Appendix L - The Sandstone Precinct– SSD 6751 MOD 2 and SSD 7484

Response to Government Agency Submissions

Blue indicates additional shadow

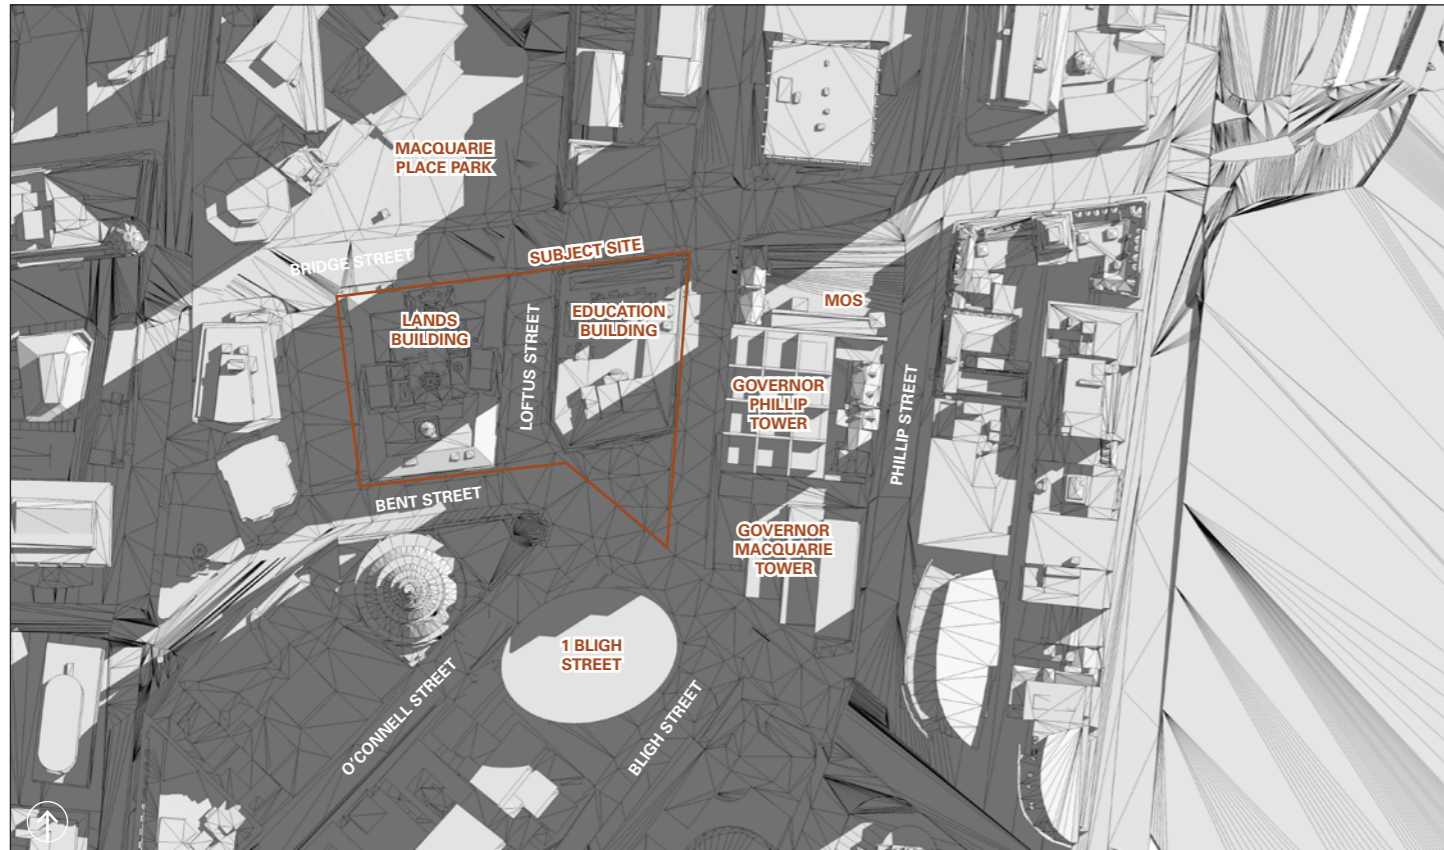
<ul style="list-style-type: none"> Any increase to the roof level of the Education Building would impact upon solar access of Farrer Place and is not supported. 	Additional shadow diagrams have been prepared that demonstrate the shadowing of Farrer Place under Stage 2 is less than that of the approved Stage 1 envelope (Refer to Appendix J).
<ul style="list-style-type: none"> Both the Lands and Education buildings are of State Heritage significance and should be treated accordingly. Lessening the impact on one building only to justify increasing heritage impact on another is not an acceptable heritage outcome. 	Noted. The use of the proposed buildings and roof envelope of the Education Building was approved at Stage 1.
<ul style="list-style-type: none"> The Trust voices its concerns about the potential decrease in public space in Farrer Place through the construction of a new vehicular drop-off leading from Bent Street. 	The reduction of public space by the new drop off will be offset by the increased public space created at the intersection of Loftus Street and Bent Street. The nett result is that Farrer Place will remain the same size.
